RE: Residential Garage – *Review of Plans and Recommendations*
MCA #2202

McGee Consulting Associates, Inc. (MCA) was asked to review whether the Residential Garage plans prepared by you meet the requirements of the current North Carolina Building Code (2018 NCBC).

FOUNDATION DETAIL
(SECTION VIEW)
(TYP. OF 9)

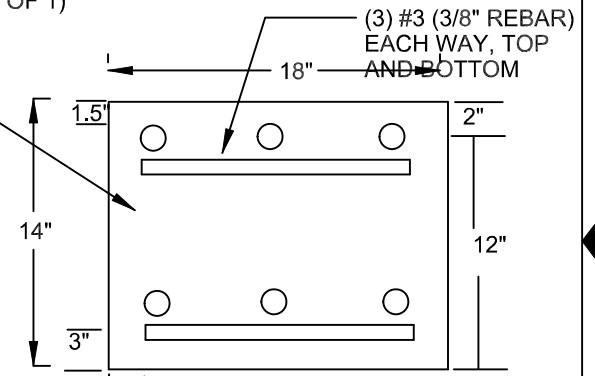
MCA determined that the columns and footings will need to support a load of 3,800 lbs based on the proposed layout. The HSS3x3x1/4 columns will support a load of 20,460 lbs, so the columns will sufficiently support the actual loads. The 18"x18"x14" footings will support a load of 4,500 lbs based on nominal 2,000 psf bearing capacity soil recommended in the 2018 NCBC, so the footings will support the actual loads.
